**PR-2023-009591**

SD-2023-00214 – PRELIMINARY/FINAL PLAT

REQUEST: DIVIDE EXISTING TRACT A INTO TWO NEW TRACTS

**Project Name:** 1224 Bellamah Ave. NW.

EXHIBIT
SITE PARKING

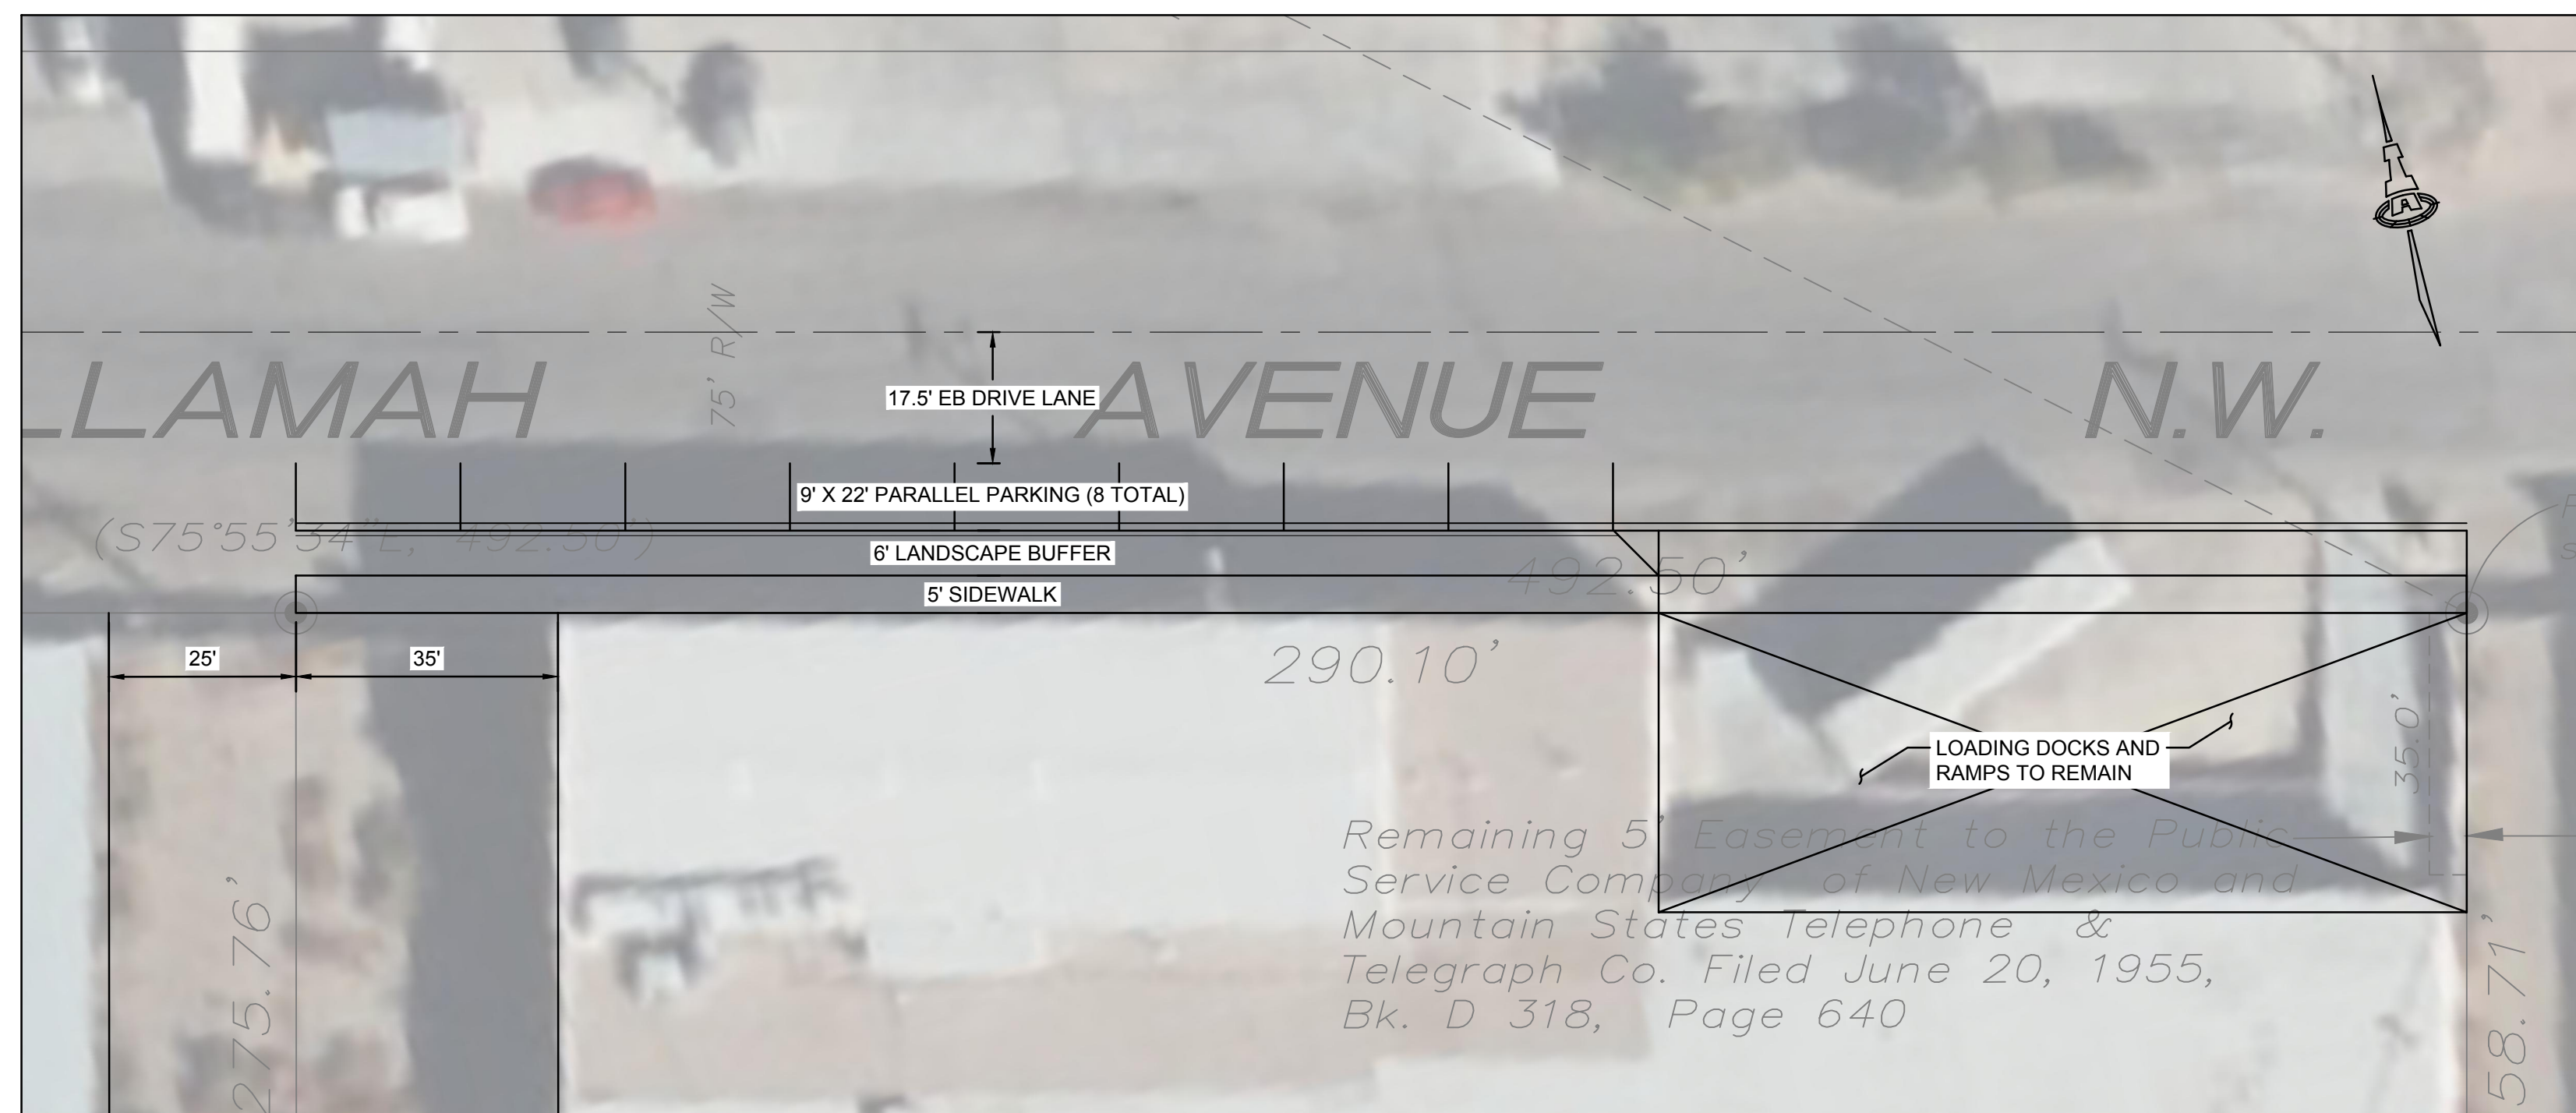
1. Future development must meet all parking requirements as per IDO 5-5, Table 5-5-1. Please clarify type of business remaining in existing building to the east on Tract A-1, and where parking for that is located.  
Note: Warehousing = No Requirement, Wholesaling and distribution center = 1 space/2000 sq ft GFA

2. No other concerns or objections from Code Enforcement. Just need clarification as to whether the re-plat is impacting/removing required parking for the remaining building on Tract A-1.

- Please demonstrate that parking calculations for the existing development and new lot are being met. Clarify if a shared parking agreement will be needed. Please include the detail for parking ROW area and curb/gutter.
